From: Michael Eastham
Sent: 13 December 2018 13:09
To: Planning.Responses
Subject: FW: Planning Consultation on LU/345/18/DOC
Importance: High

Registered: 28-NOV-18
Site Address: Land North of Toddington Lane Littlehampton BN17 7PP

Description of Works: Approval of details reserved by condition imposed under ref LU/47/11/ relating to Condition Nos 10 surface water drainage scheme, 11 future access to & maintenance of any watercourse or culvert, 12 discharge of any flows to watercourse, 13 foul water drainage system.

Figure 3.1 Existing Lagoon and Ditch (in green) to be filled in

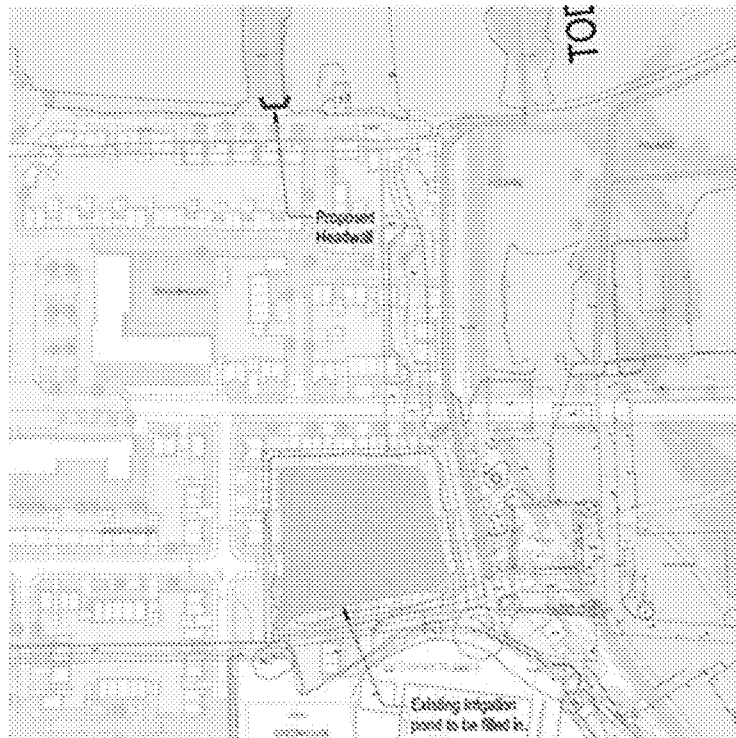
No evidence has been submitted of formal written acceptance of the proposals to infill the watercourses shown in Figure 3.1 of the drainage strategy. Therefore, I do not recommend the discharge of this condition.

The only watercourse and ditch affected by the proposed development will be the irrigation lagoon and its overflow, which are no longer required to serve the consented scheme. We understand that the ditch is not yet filled in and the works will form part of the future planning submission for the remaining section of phase 2 that extends into the wetlands.

We will liaise with our Client to find out if a specific application has been submitted to fill this ditch in. If not we will organise for one to be submitted asap.

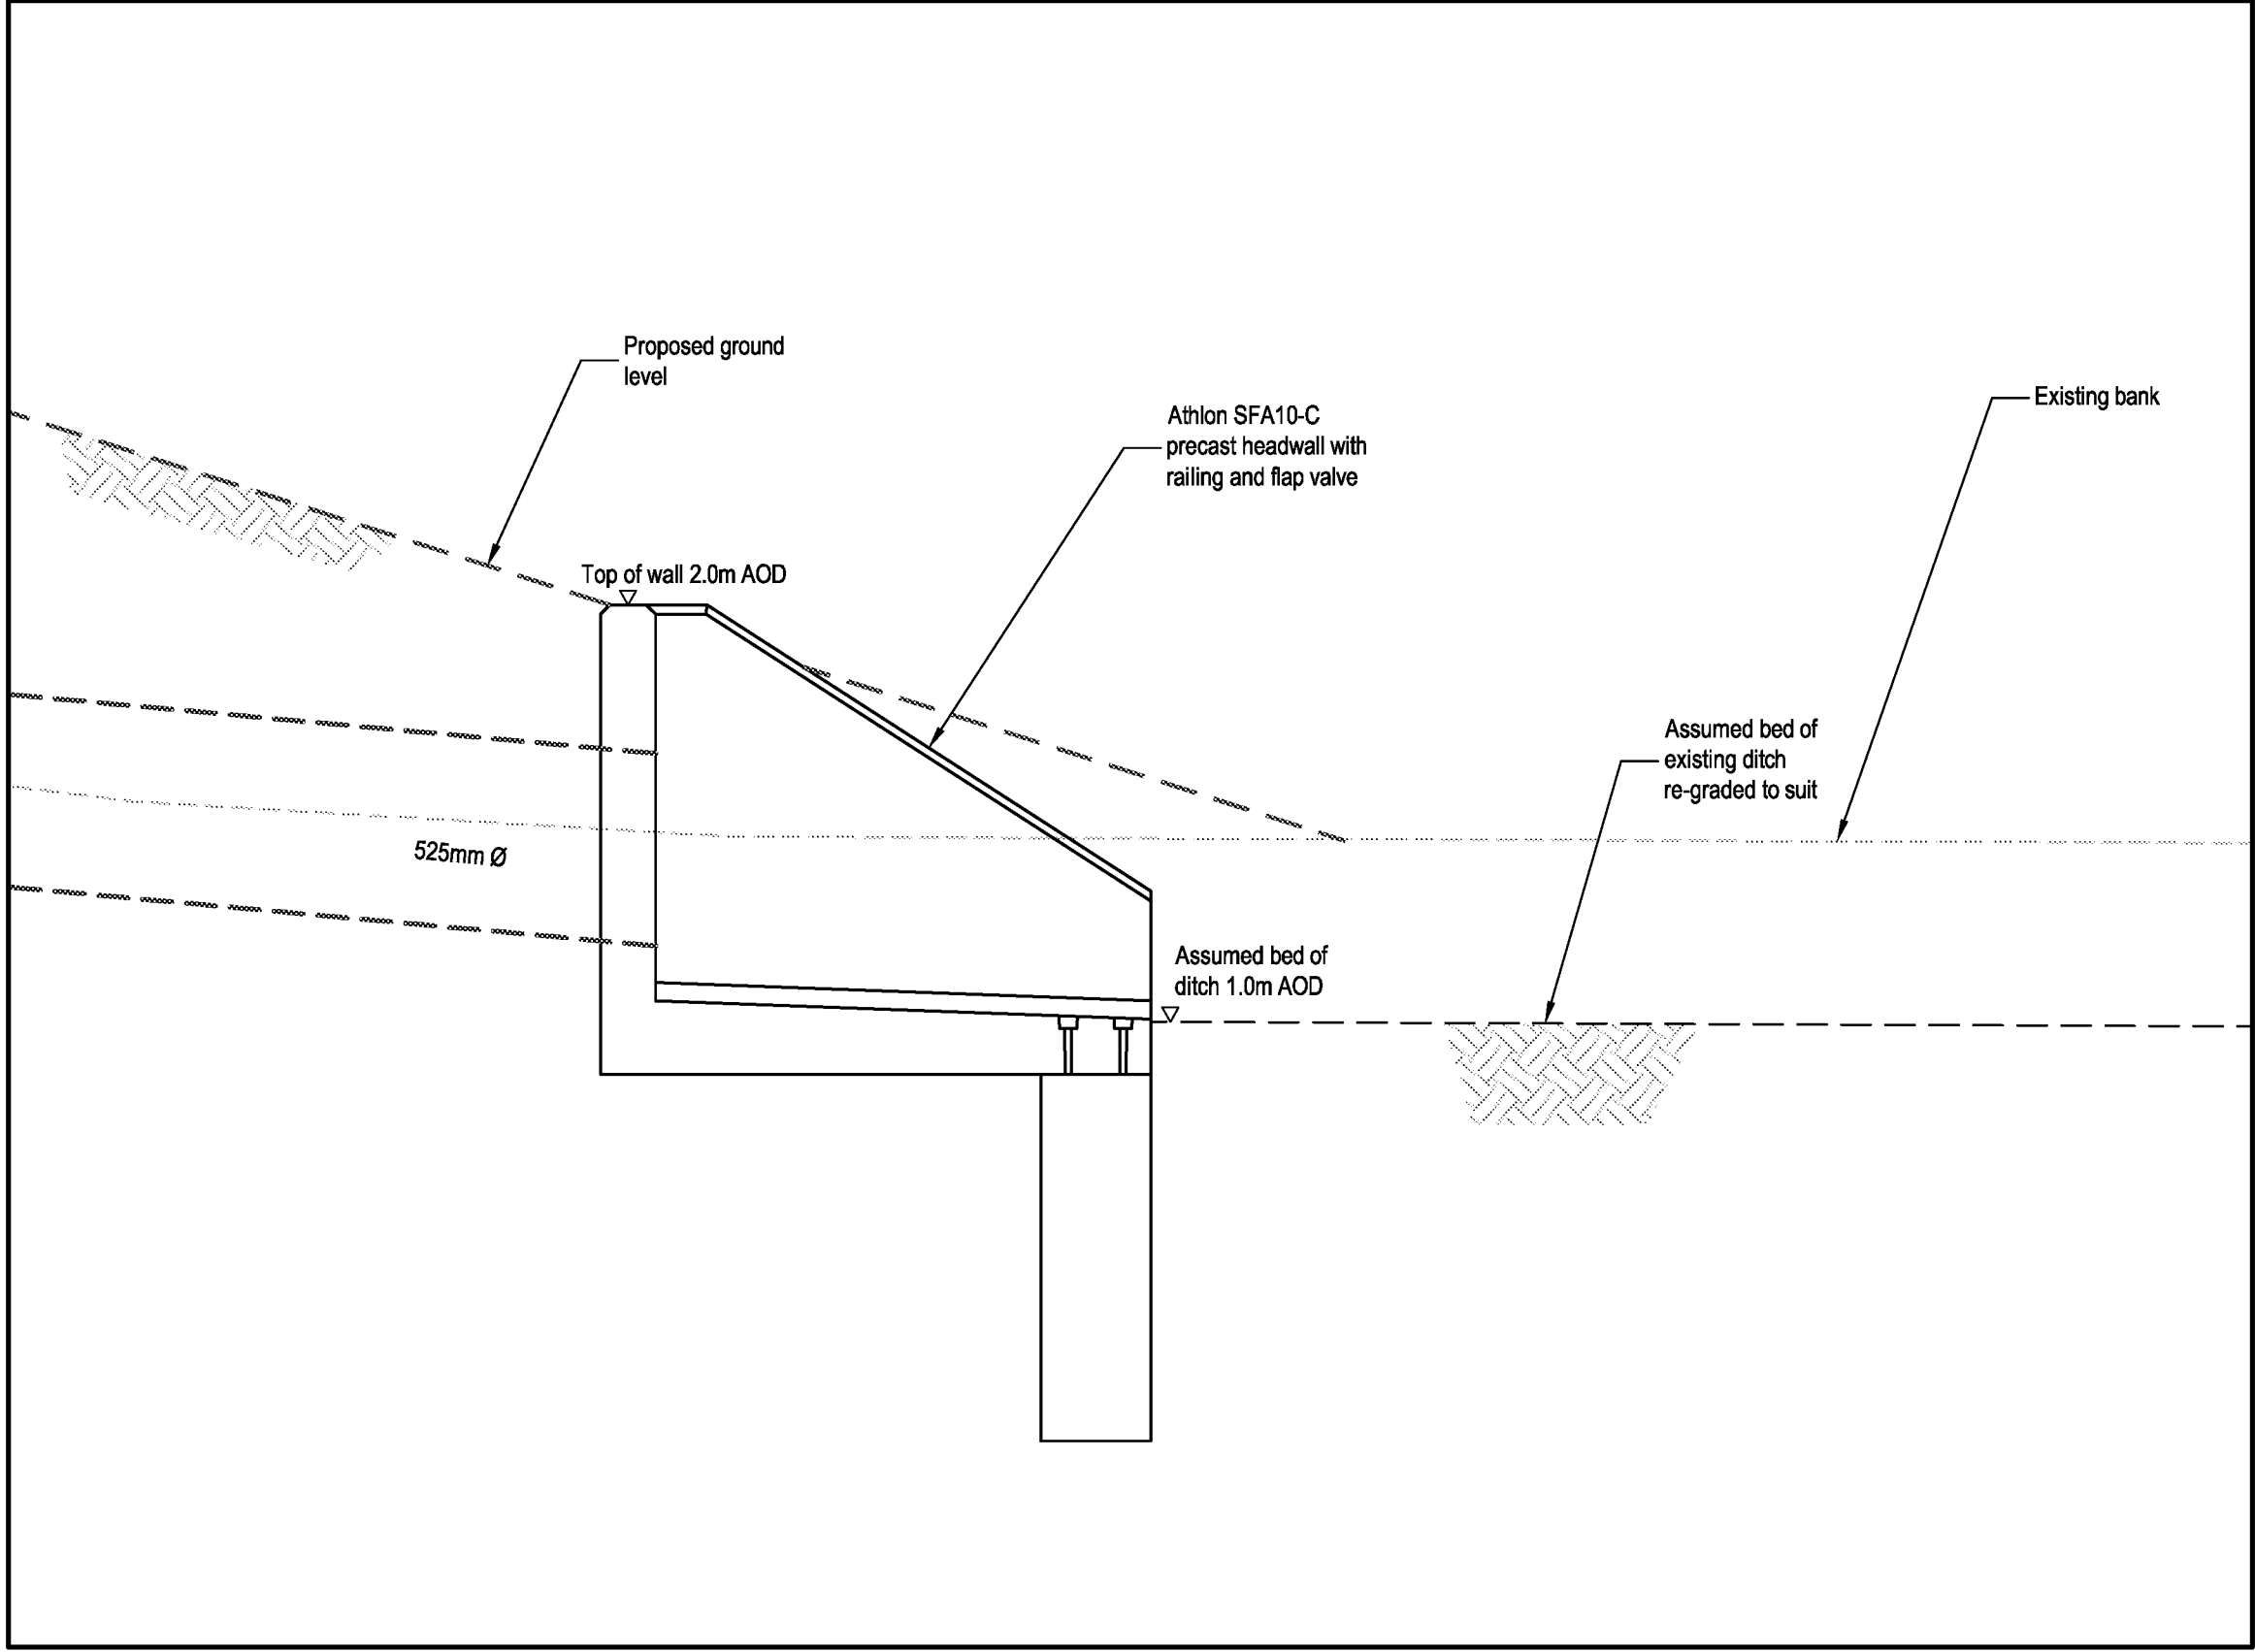
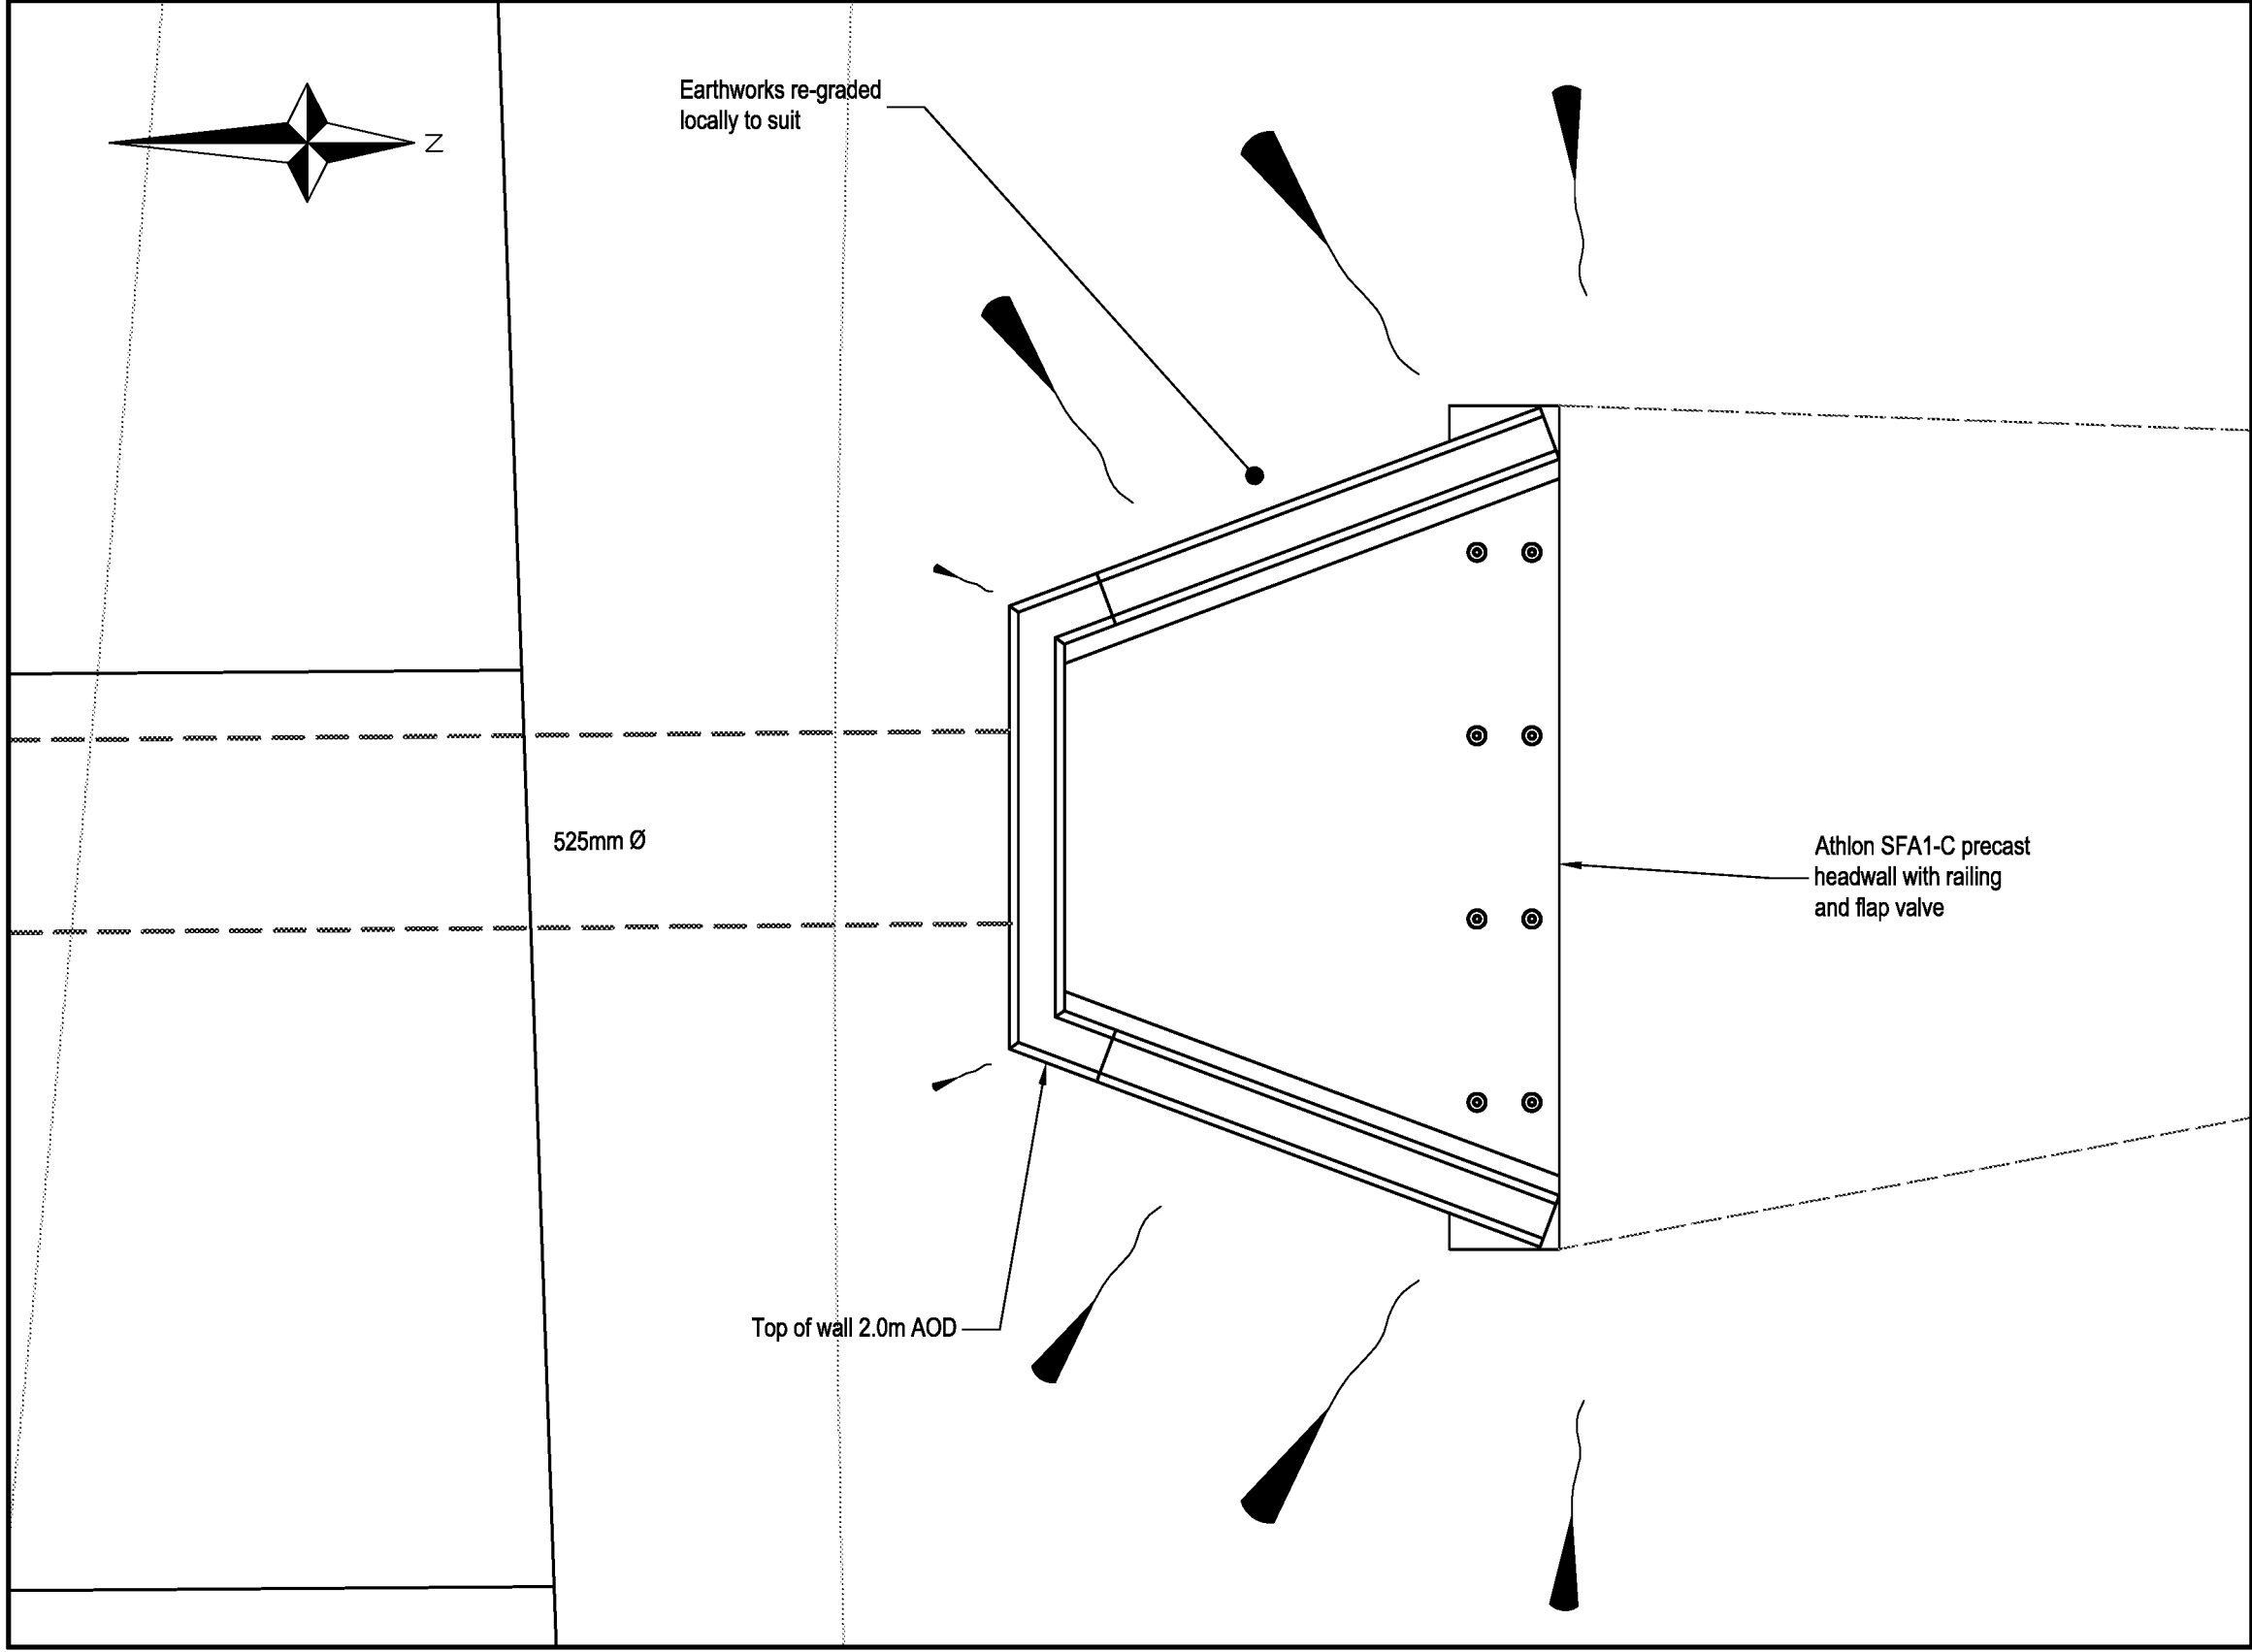
A FRAP has been obtained from the Environment Agency to construct a headwall in the Black ditch. However, no evidence of the acceptance of infilling has been provided, nor for any over proposed structures. Therefore, I do not recommend the discharge of this condition.

We are surprised by this response because we believe the Flood Defence Consent for the new outfall (granted by the Environment Agency) into the ditch would be adequate because it includes a description of the works and information on the new headwall.

Description of works: Construction of 1 no. precast concrete surface water outfall (with railings and flapvalve) to take discharge from new development through 525mm diameter pipe.

As detailed on Drawings: 8140927/SK12, CV8140927/SK09 and SFA 10C
Headwall Plan
